**Gascoyne Cecil Estates ["GCE"] Planning Application
for Replacement Car Parks
Application number S6 2010/1711/FP**

I am writing to you with comments, observations and objections in relation to the above Planning Application.

DRAWING TITLE:
 SITE PLAN

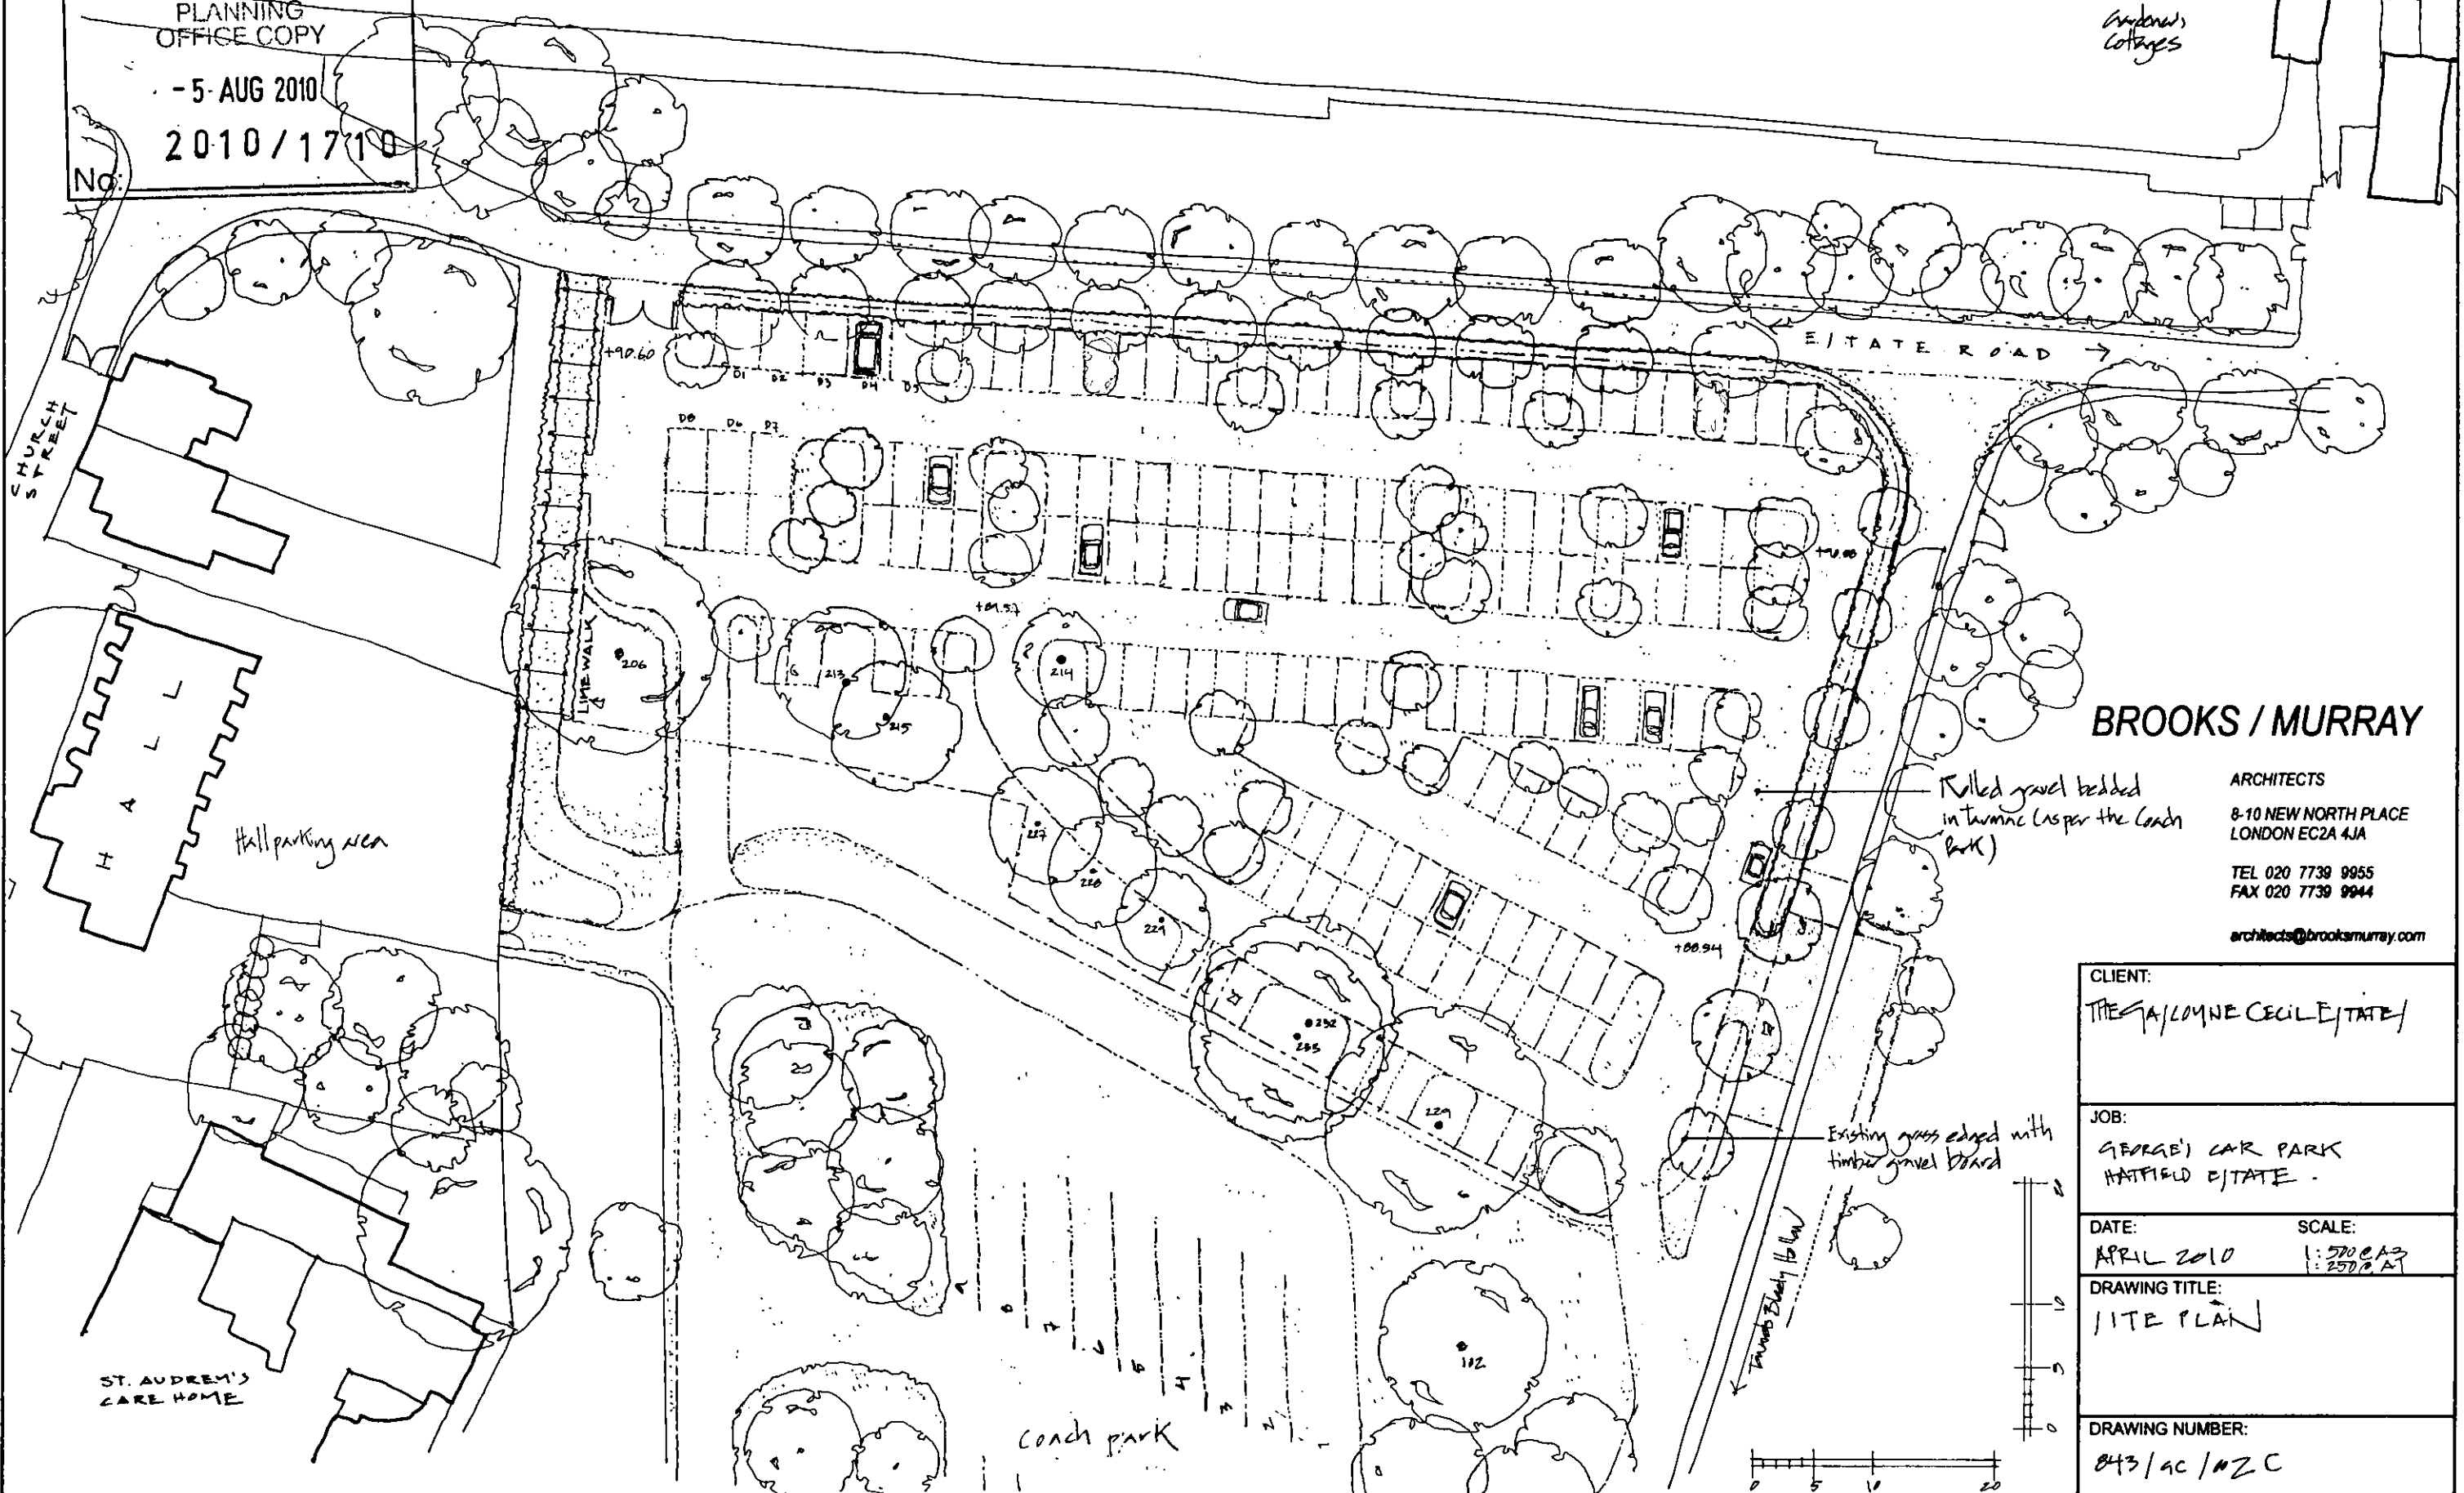
However I have concerns that the proposals for Georges Field [Planning Application 1] will be insufficient to meet future visitor demand.

SPS states that the proposed Georges Field car park will be the main entrance for visitors [page 15, para 4.1], with parking spaces for 148 vehicles [p4.2], effectively replacing both NF/CP* car parks [p4.3]. Until now on busy days "overflow" car parking has been accommodated along the tree lined North Avenue leading to Hatfield House [p3.2]. Even now, with 152 parking spaces in NF [p3.1] and 59 in CP* [p4.13] there are, on busy days, more than 250 vehicles parked in the vicinity at any one time. Given the expected visitor increases during the 400th celebrations [p4.11] and the likelihood that other planned new attractions [p1.7; p4.9] will boost demand over the coming years it would seem that the proposed 148 parking spaces in Georges Field will be inadequate to meet demand at peak times.

Looking at the Site Plan [Figure 6 on pages 14/15 of SPS] there appears to be no provision for overflow parking at Georges Field.
